Transport
Roads & Maritime
Services

CE12/0536
NWRL EIS1

MP 06_0157 NORTH WEST RAIL LINK (NWRL) – STAGED STATE SIGNIFICANT INFRASTRUCTURE MODIFICATION AND STATE SIGNIFICANT INFRASTRUCTURE APPLICATION – MAJOR CIVIL CONSTRUCTION WORKS (SSI-5100).

Figure 1: Suggested Traffic changes for Intersection of Franklin Road and Castle Hill Road

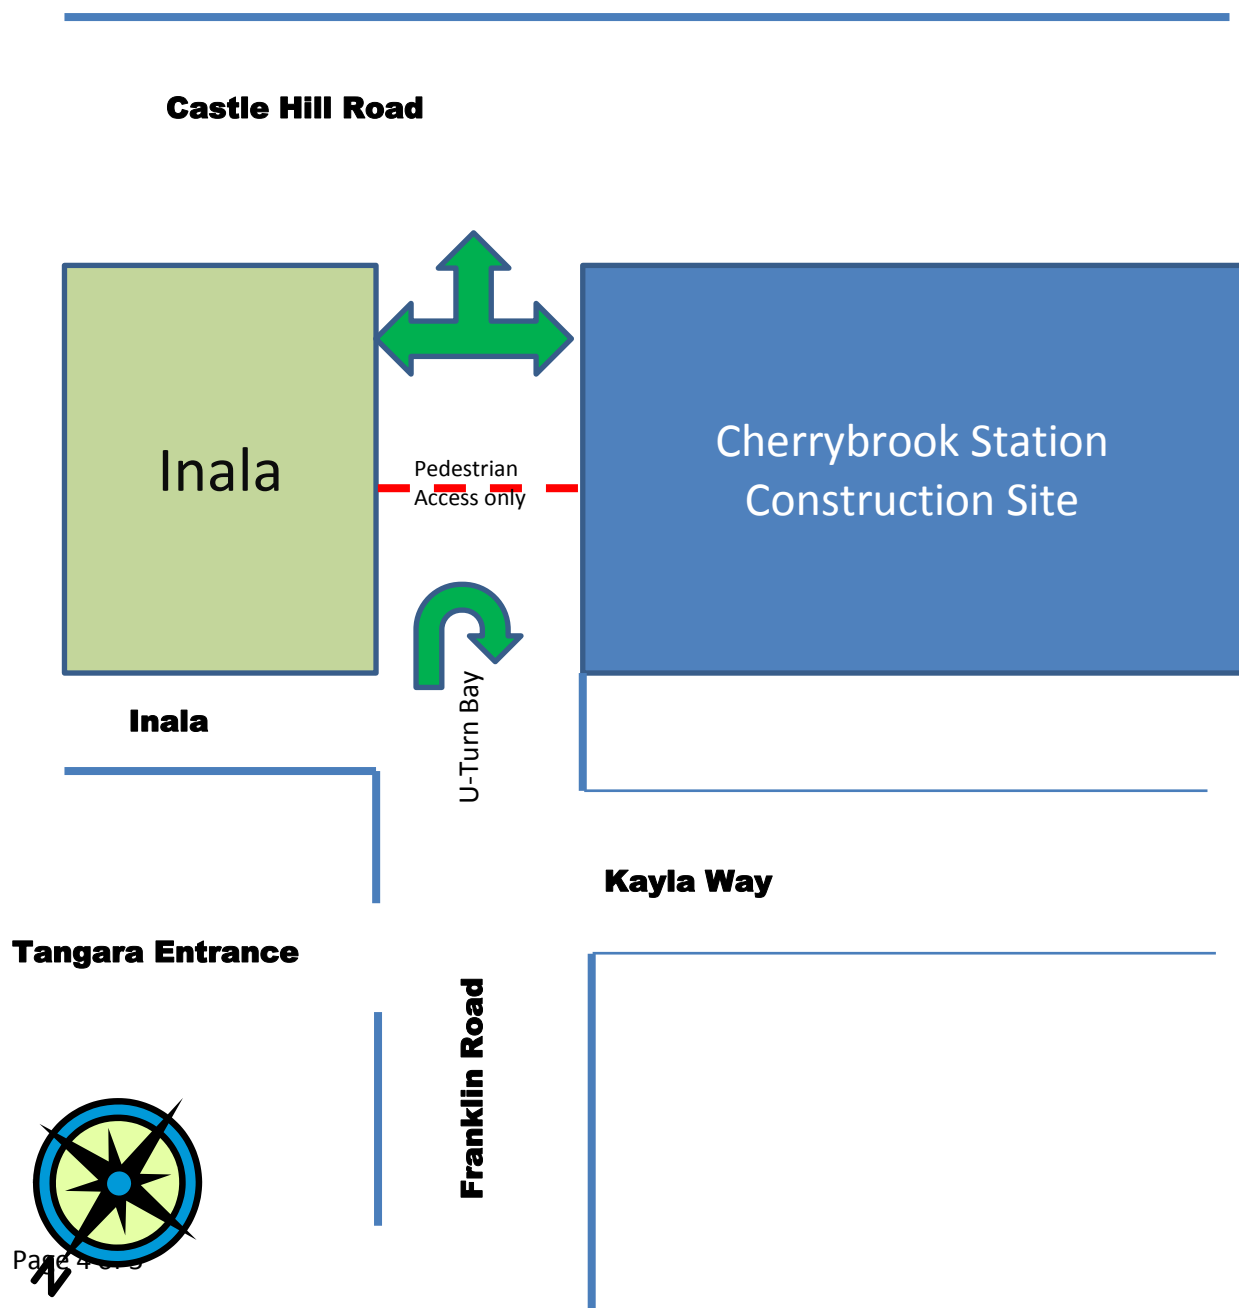
- The proposed signalisation of the Castle Hill Road/Franklin Road intersection must be designed to include the following:

- Comply with relevant Austroads and RMS supplements sight line requirements,
- The banning of right turn movements from Castle Hill Road into Franklin Road,
- Provision of separate left and right turn approach lanes within Franklin Road,
- Separate long left turn lane from Castle Hill Road into Franklin Road,
- Appropriate pedestrian crossing facilities.

Signalisation of this intersection would be subject to the provision to a suitably designed layout and appropriate consultation with Council/affected parties.

Approval to the signalisation of the intersection will only be granted in consideration of the construction activities, RMS reserves the right to remove the proposed signals at the Castle Hill Road/Franklin Road intersection at any time after the completion of the construction of the NWRL.
